Your Ref
BN/5/19/DOC
Our Ref
PLAN-027046
Date
08/03/2019

**Proposal: Approval of details reserved by condition imposed under ref
BN/49/18/PL relating to Condition Nos 3, 4, 5, 6, 10 and 11.
Site: Land at Former Pollards Nursery, PO22 0AF.
BN/5/19/DOC**

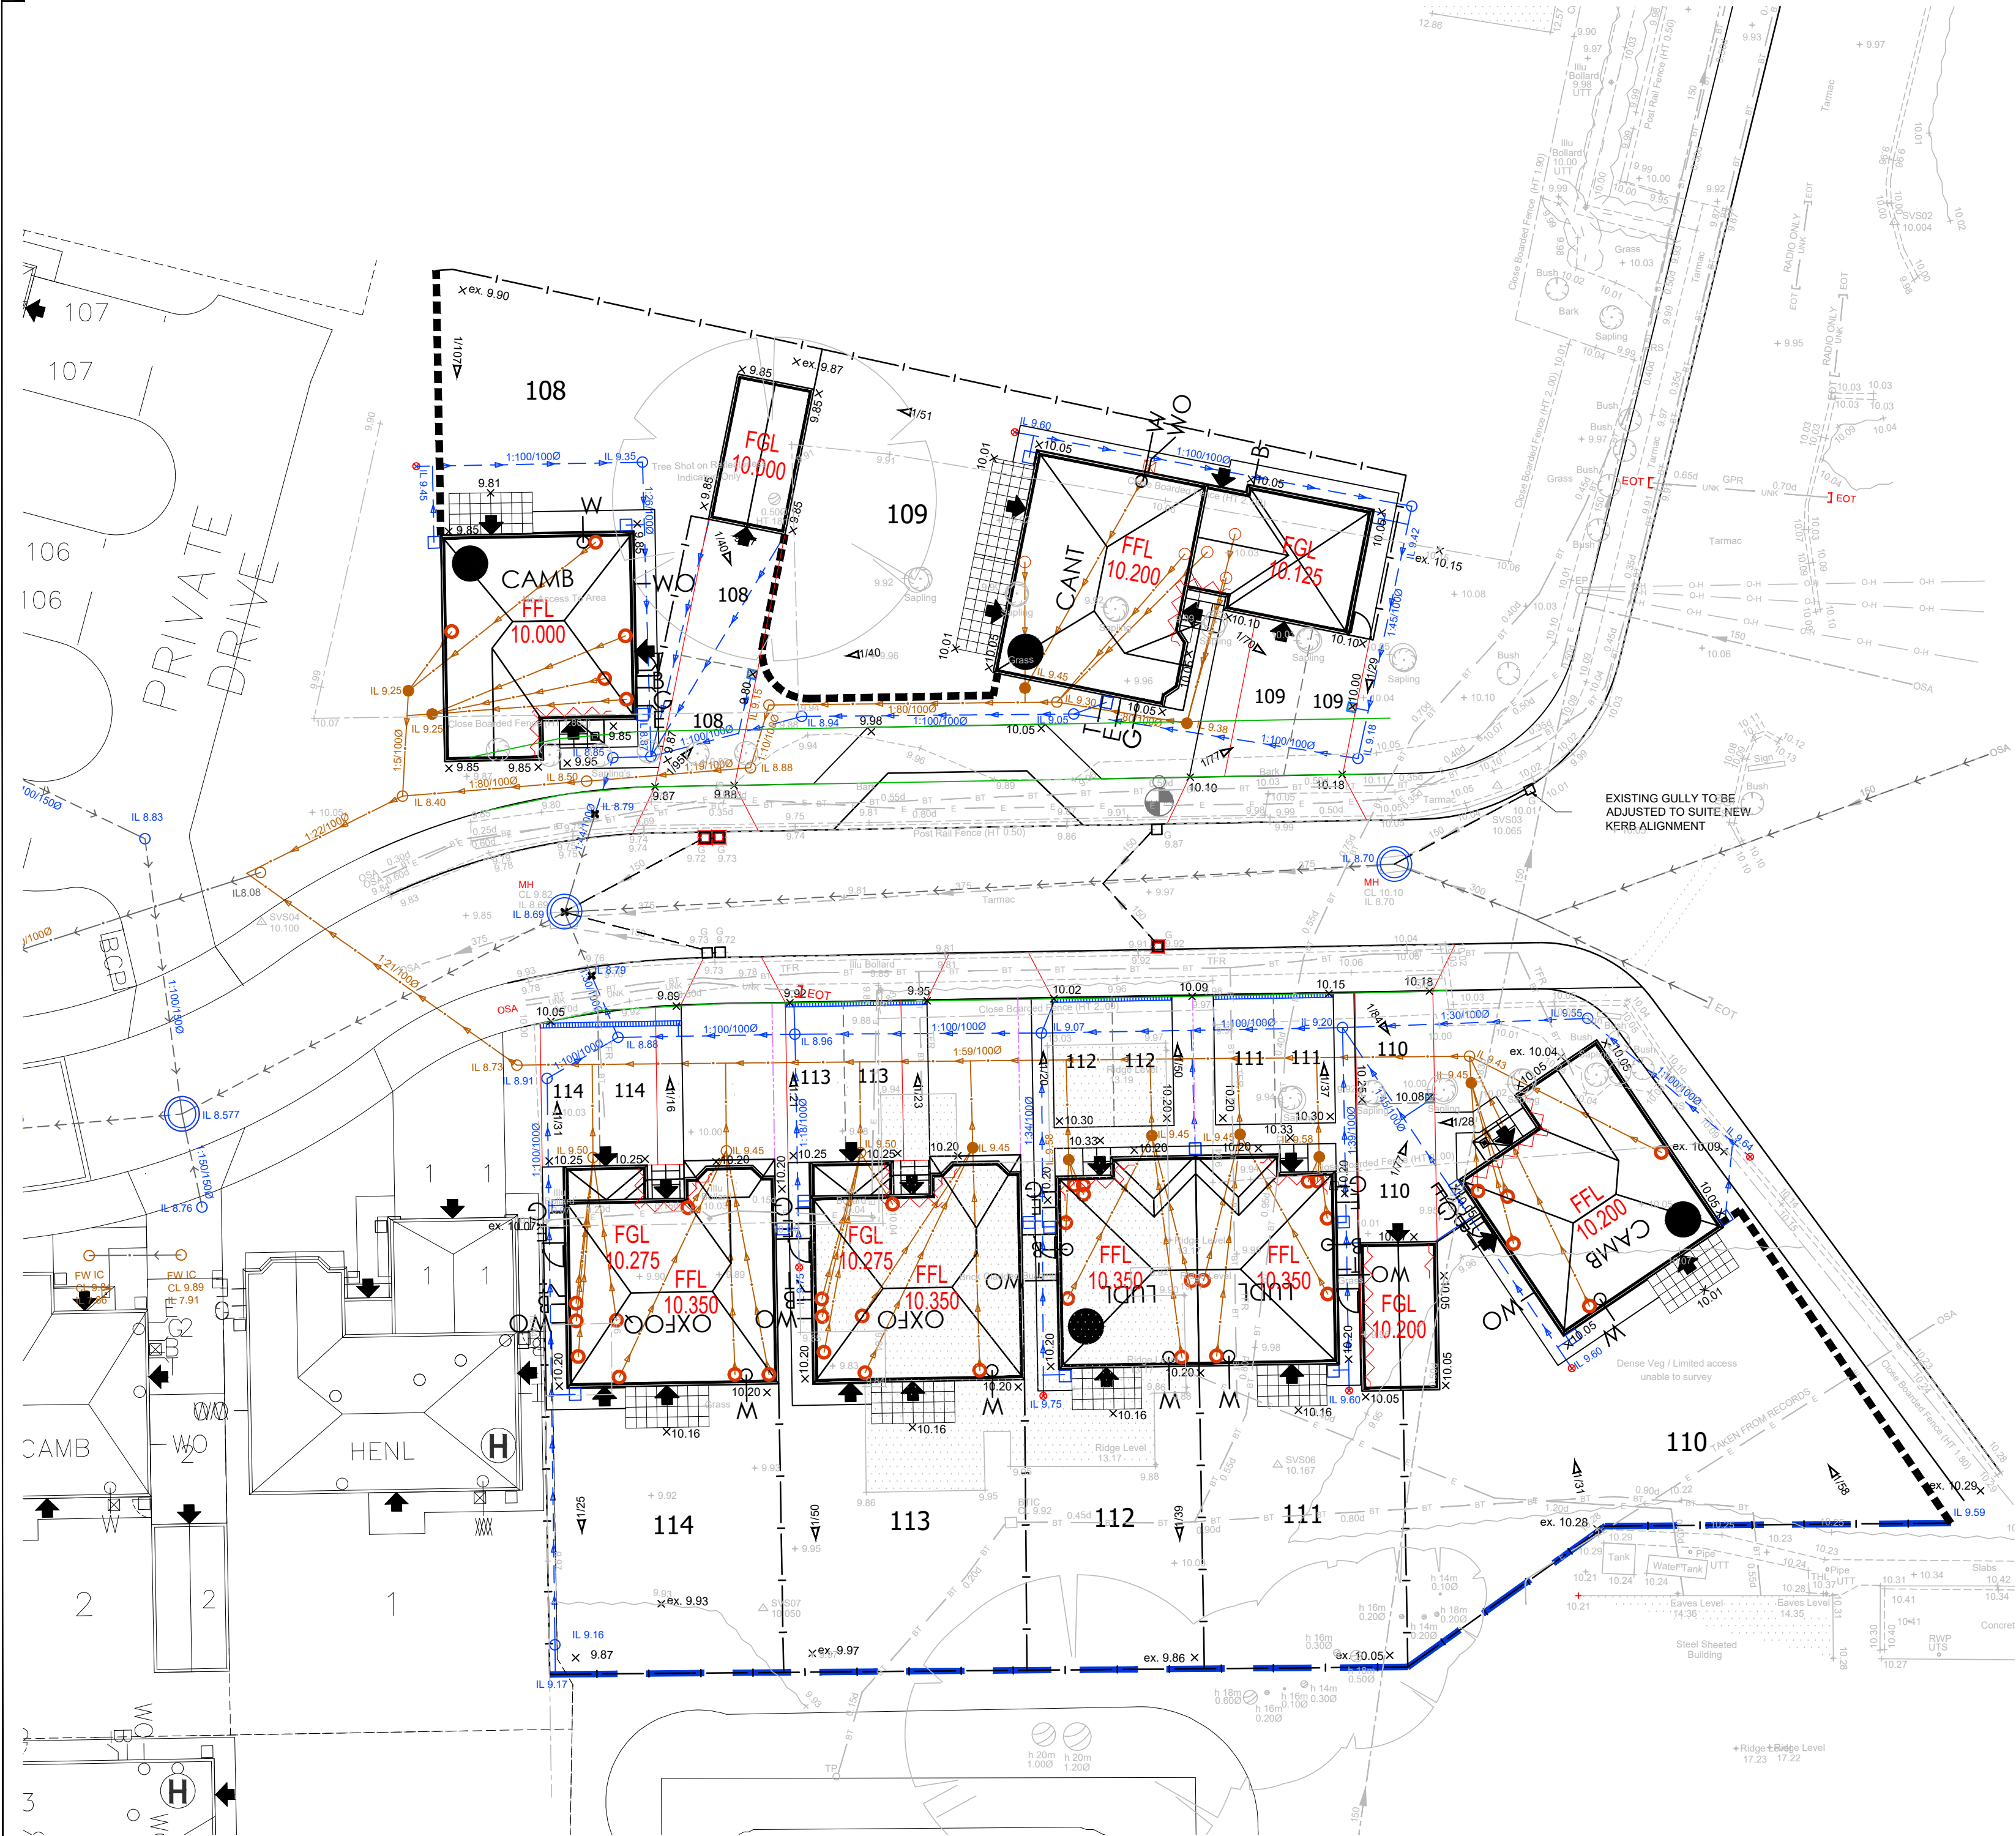
Southern Water does not recommend discharge of condition 5 and 10 as final discharge point to the foul and surface water sewer has not been indicated.

Kindly submit a detailed drainage layout plan, clearly indicating the on-site foul and surface water drainage and their relevant discharge points.
